LIBERTY TREE ACADEMY
DRAFT PRELIMINARY DRAINAGE REPORT

PPR-18-023

LIBERTY TREE
ACADEMY

FIGURE A-2. EXISTING DRAINAGE PLAN

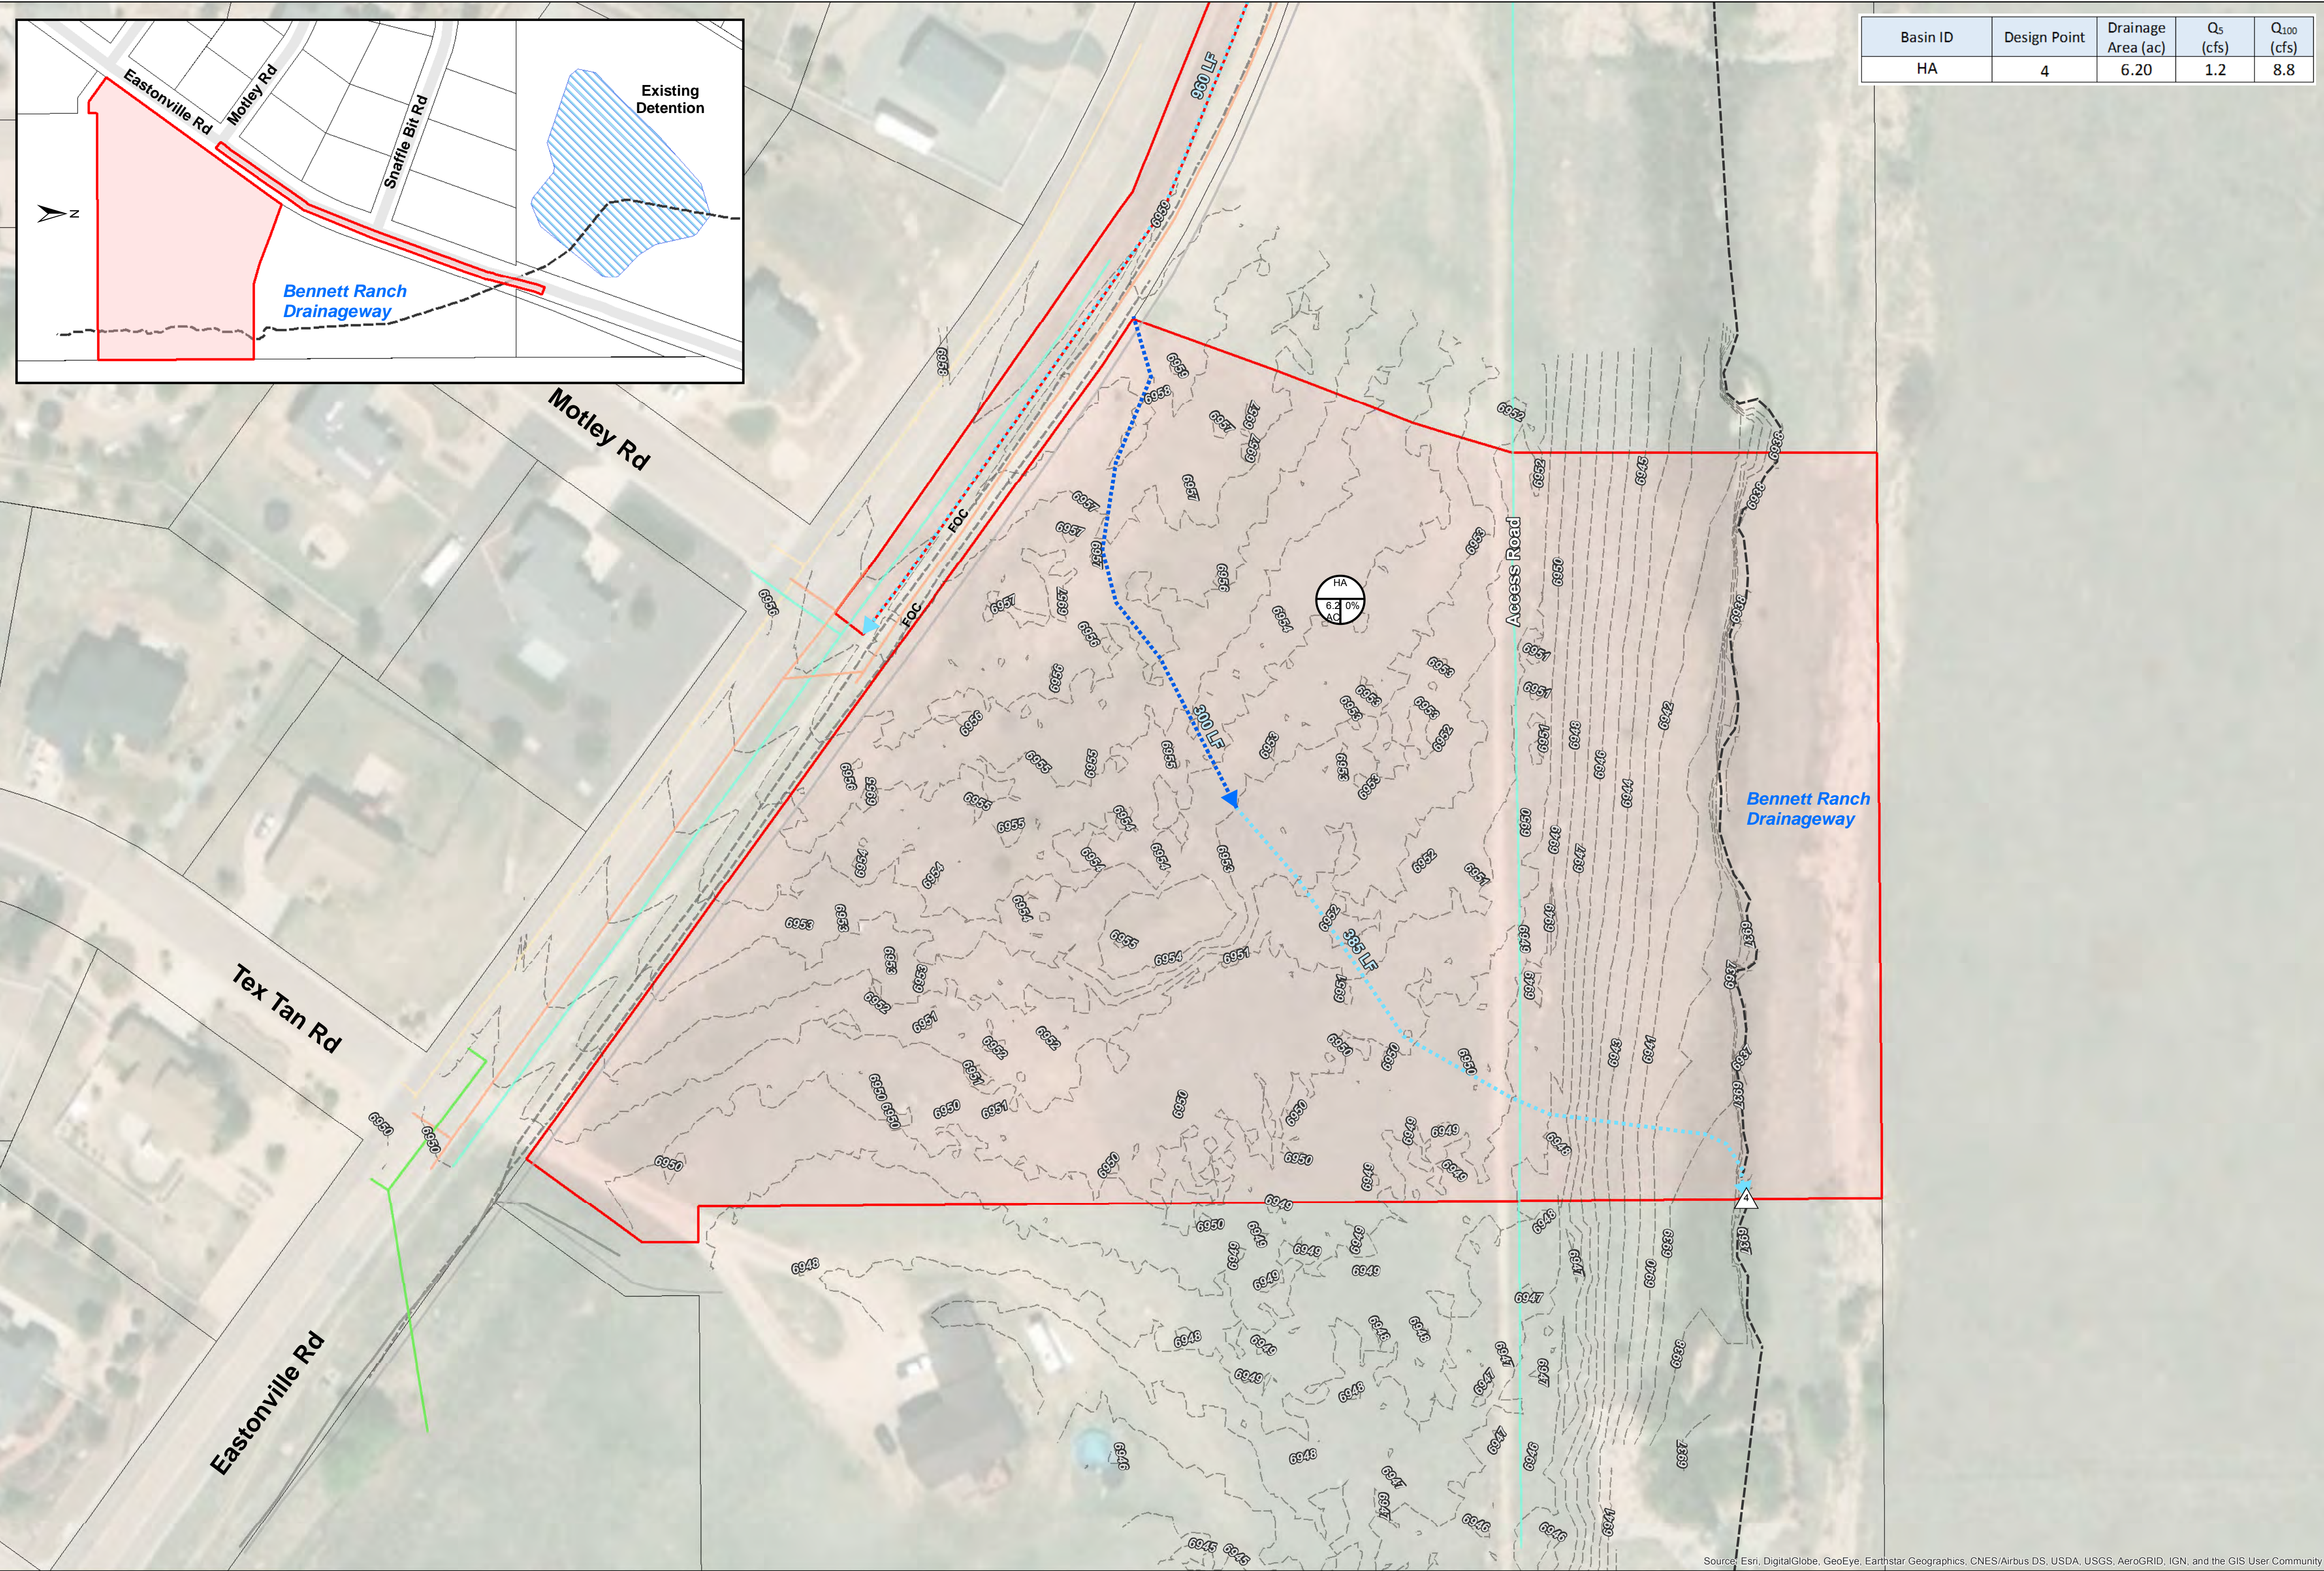
Provide Existing
Drainage Plan
